Revise title to "Preliminary Plan for Abert Ranch Subdivision"

# ABERT RANCH SUBDIVISION

## A Rural Residential Subdivision in the NE Quarter of Section 23 and in the NW Quarter of Section 24, Township 11 South, Range 66 West of the 6th P.M., El Paso County, Colorado.

Preliminary Plan for ABERT RANCH SUBDIVISION

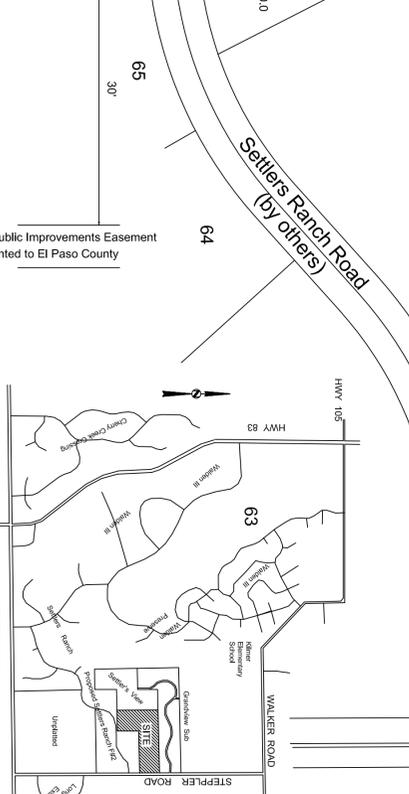
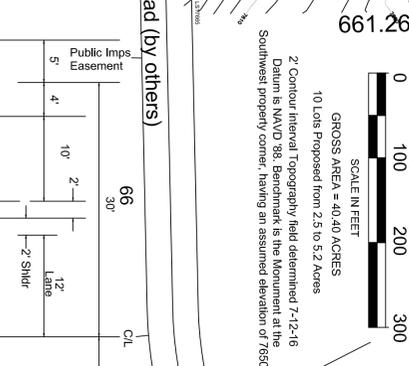
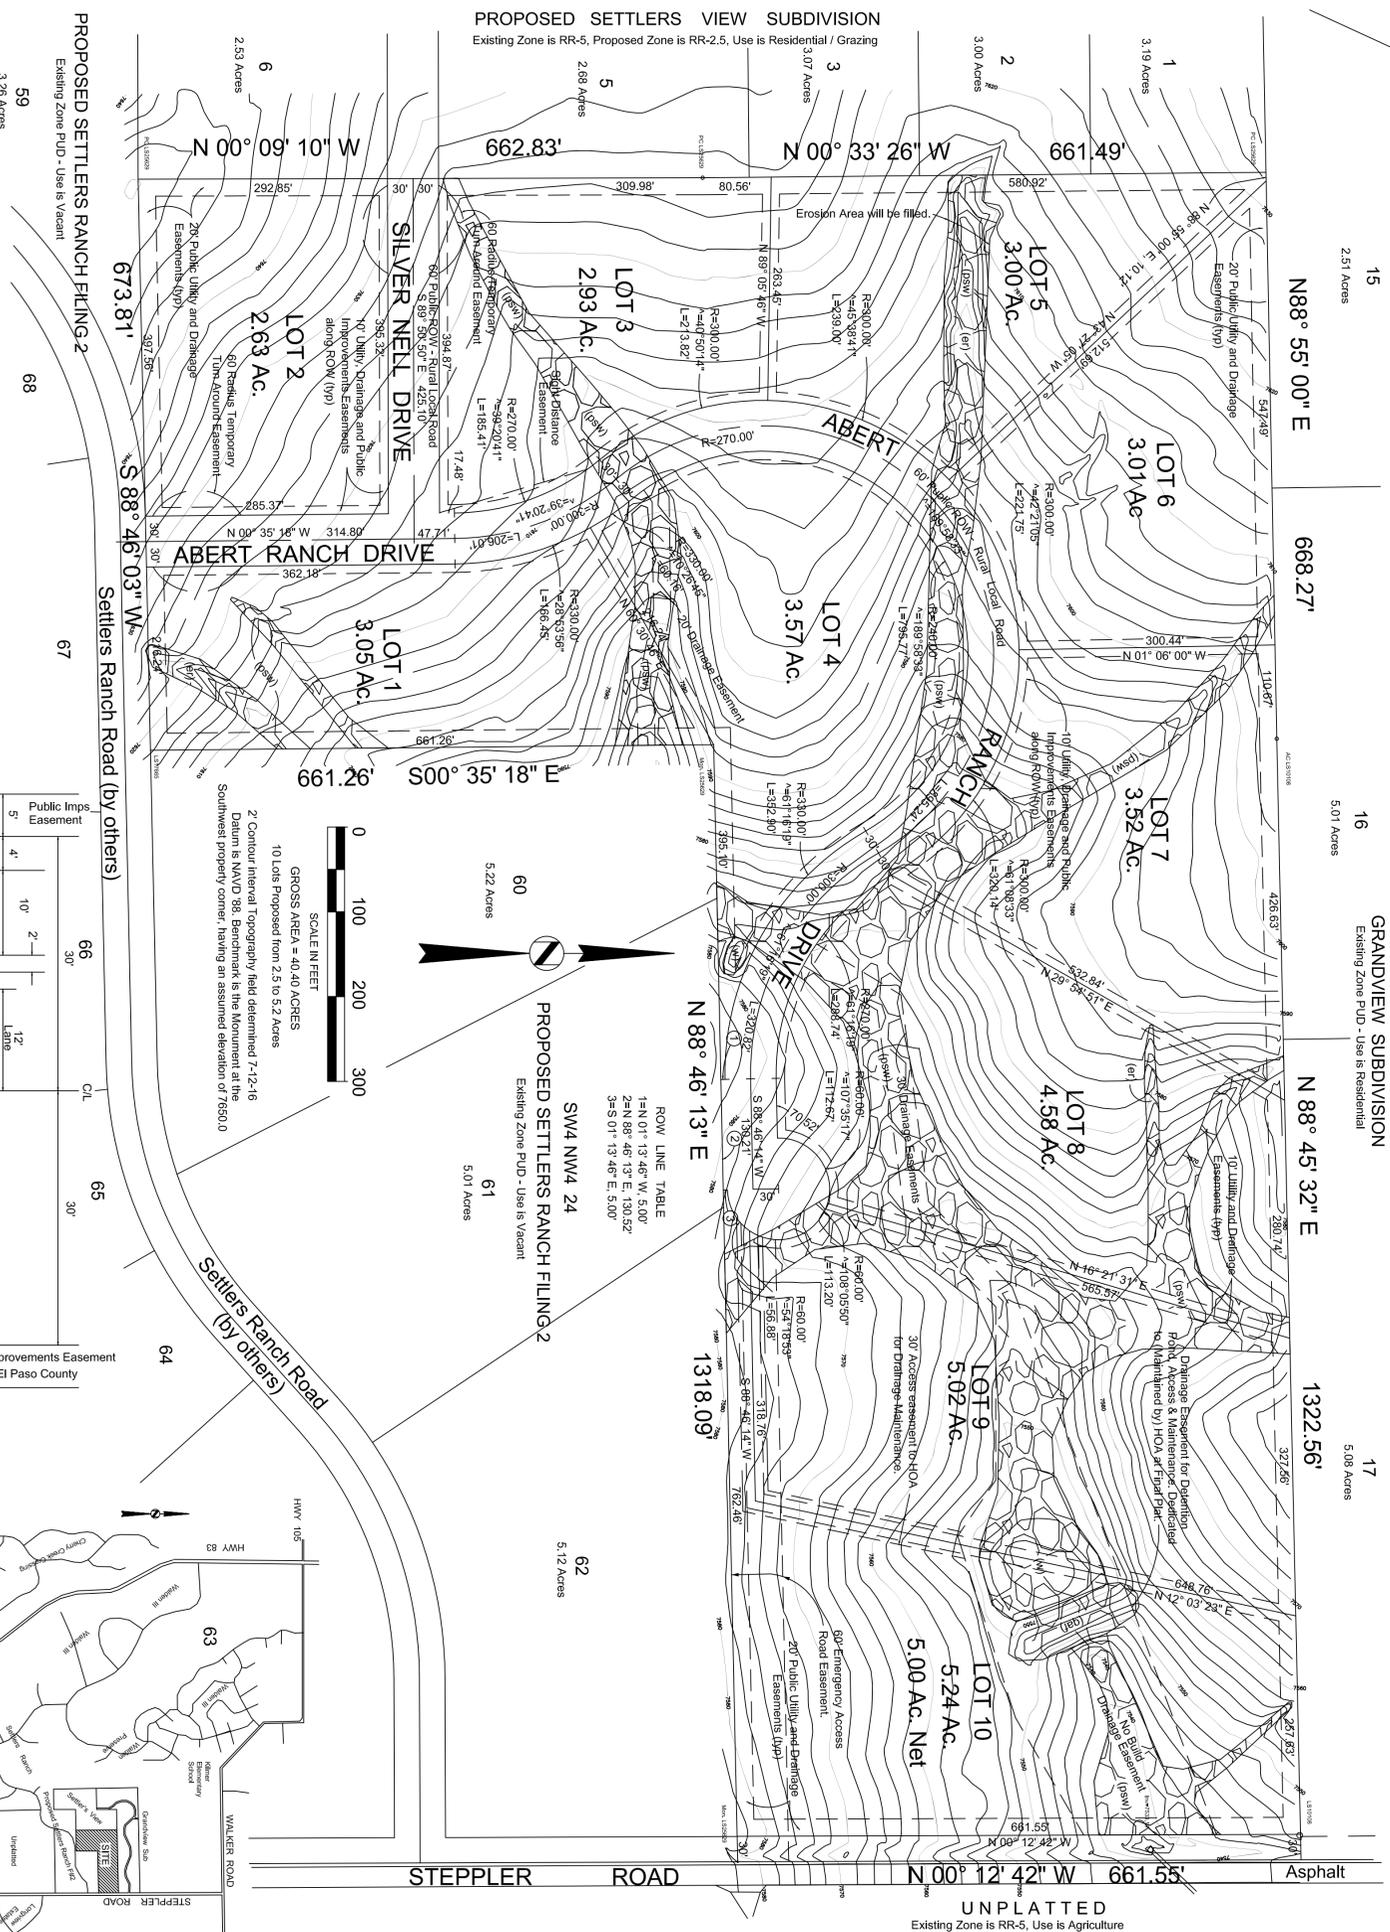
See ECM Section 2.3.6.G for intersection sight triangle easement procedure. Additional sight triangle easement is likely required at the highlighted area. Add a note that any object within the sight distance triangle or easement more than 30 inches above the edge of asphalt of the adjacent roadway shall constitute a sight obstruction, and shall be removed or lowered.

Add a typical roadway cross section detail for the Temporary Emergency Access road.

Revise title to "Preliminary Plan for Abert Ranch Subdivision"

Revise callout to "60' Temporary Emergency Access Easement". Add a note that the temporary access shall be removed and easement vacated when the Abert Ranch Drive and Settler Ranch Road intersection is constructed. An escrow is required with the final plat for the removal of the temporary access.

Label the street classification and ROW width.

Per ECM Table 2-5, minimum centerline radius is 300 ft. Revise or submit a deviation request.

Add the criteria language for the temporary cul-de-sac identified in ECM Chapter 2 Section 2.3.8.C (pg 2-63). The note must also be added in the final plat.

Depending on the timing between Settlers View and Abert Ranch, the first developer to construct will be required to install the temporary cul-de-sac at the interface between the two development while the second developer will be required to remove the temporary cul-de-sac when the connection is made.

If both subdivision construction occurs simultaneously, the temporary cul-de-sac may not be required.

It's unclear which lot this sliver of land belongs to.

Show the proposed drainage and access easement for the detention pond. Identify who maintains the pond.

Add a typical roadway cross section detail. Per the EPC standard detail for Rural Local Roadway, a 5' public improvement along the ROW shall be granted to El Paso County.

Note on the plan that Lot 1 and 2 shall not have direct lot access from Settlers Ranch Road and Lot 10 shall not have direct lot access from Stepler Road.

Delete proposed. The rezone will be approved prior to the prelim.

Add "public"

Identify row width and "public" for all roads

Who are the utility providers to be? Add notes.

Add Geologic hazard note provided in MTD letter.  
Identify the hazard areas on map.

Add note: Water Supply: (utilized when the water supply is individual wells)  
(Note: The exact wording of plat notes regarding well water supply depends upon the language of the water decree and/or augmentation plan, and will be reviewed and approved by the County Attorney's Office)  
Individual wells are the responsibility of each property owner. Permits for individual wells must be obtained from the State Engineer who by law has the authority to set conditions for the issuance of these permits.  
Water in the Denver Basin Aquifers is allocated based on a 100-year aquifer life; however, for El Paso County planning purposes, water in the Denver Basin Aquifers is evaluated based on a 300-year aquifer life. Applicants and all future owners in the subdivision should be aware that the economic life of a water supply based on wells in a given Denver Basin Aquifer may be less than either the 100 years or 300 years indicated due to anticipated water level declines. Furthermore, the water supply plan should not rely solely upon non-renewable aquifers. Alternative renewable water resources should be acquired and incorporated in a permanent water supply plan that provides future generations with a water supply.

Add note: Sewage treatment is the responsibility of each individual property owner. The El Paso County Department of Health and Environment must approve each system and, in some cases the Department may require an engineer designed system prior to permit approval. These systems may cost more to design, install, and maintain.

Identify the adjacent zoning and land uses for all boundaries. The east boundary will have existing and proposed.

This is a GEO hazard. Identify all hazards and constraints. Use standard language.
